## Wansford Parish Council

### Deadline 9 Submission

#### Comments on the Applicant's Responses to the ExA's Additional Questions (ExQ3) Section 3.4.1 Scheduled Monument North of A47

##### A47 Wansford to Sutton Dualling

Figure 7 – The Scheduled Monument magnetometer survey by Headland Archaeology on behalf of Highways England

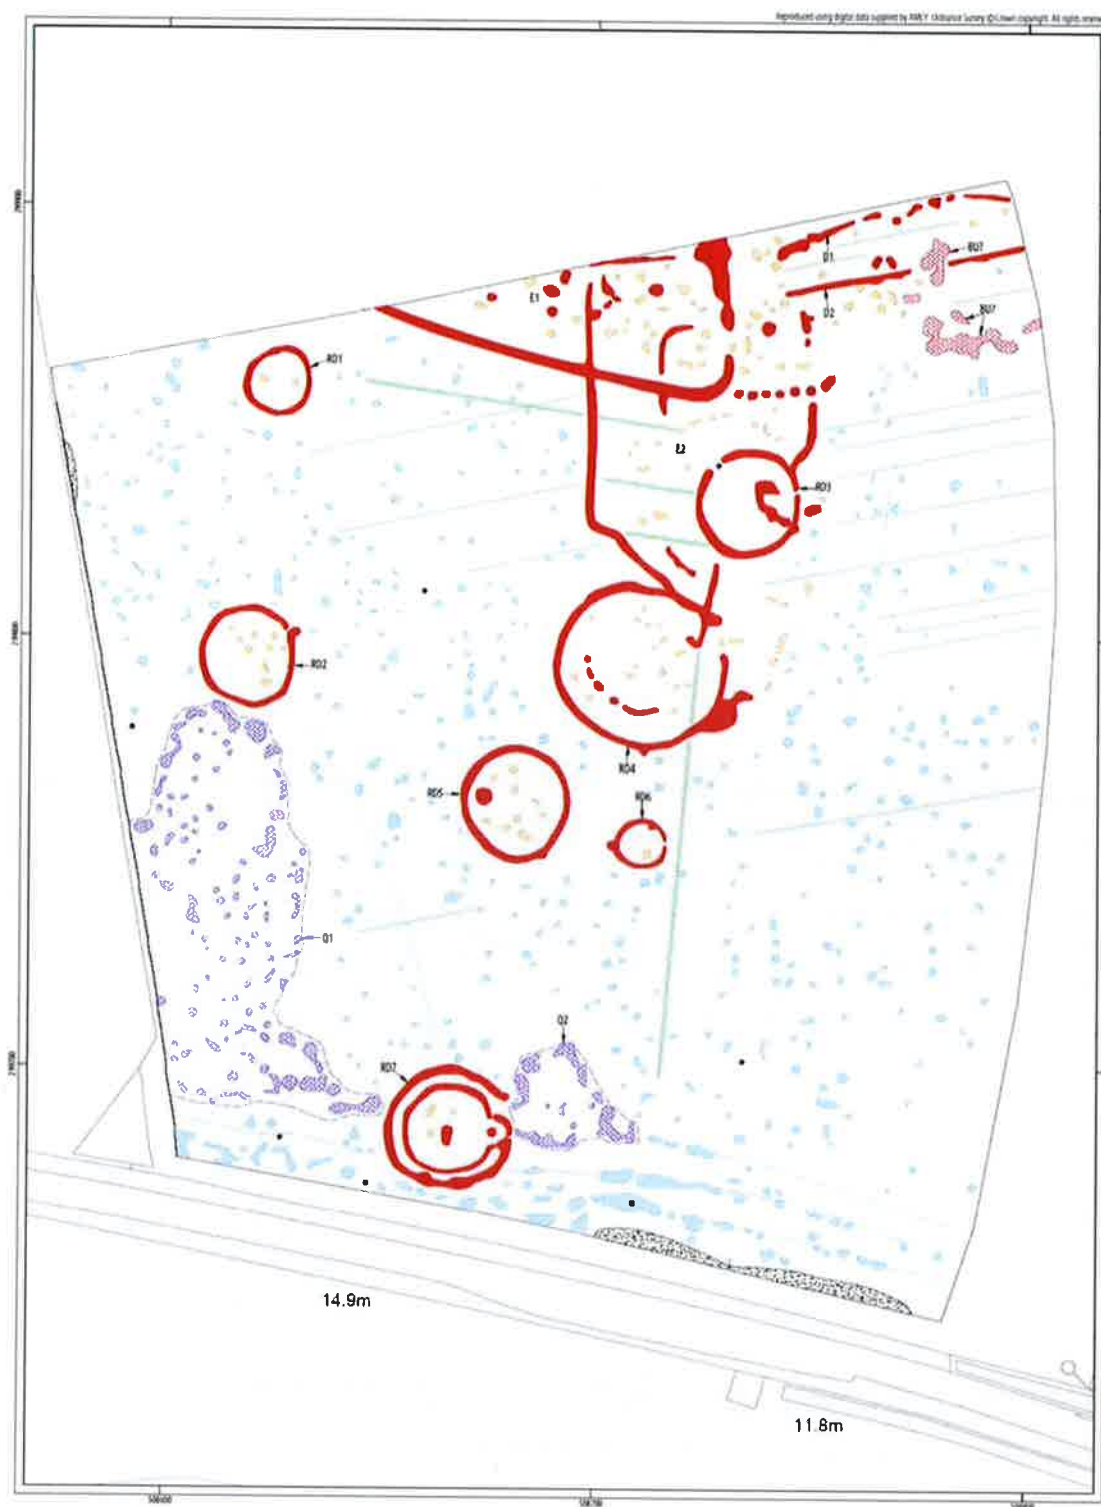
The Applicant's response is full of general comments and makes no specific reference to the actual features of the Monument. These features are very well displayed in a geophysical survey commissioned by the Applicant in 2017.

The Applicant claims that "It is very clear that earthworks, disturbance and operational impacts from a road traversing 4.865ha of a scheduled monument consisting of burial mounds could cause complete loss of archaeological artifacts and thus the loss of the significance of the heritage asset". It is not clear exactly what they are referring to as this Scheduled Monument has an overall area of approximately 6.3ha and the area covered by the road is approximately 0.6ha (a corridor 215m long and 27m wide). As the road is close to ground level and on good geology there is no need for disturbance outside this corridor. The monument contains no burial mounds as it is a level field. It does contain the remains of ring ditches and possible mounds but none of these would be touched by the alignment through the Monument.

It is very difficult to see how an alignment that does not touch any of the features of a Scheduled Monument can be described as doing substantial damage.
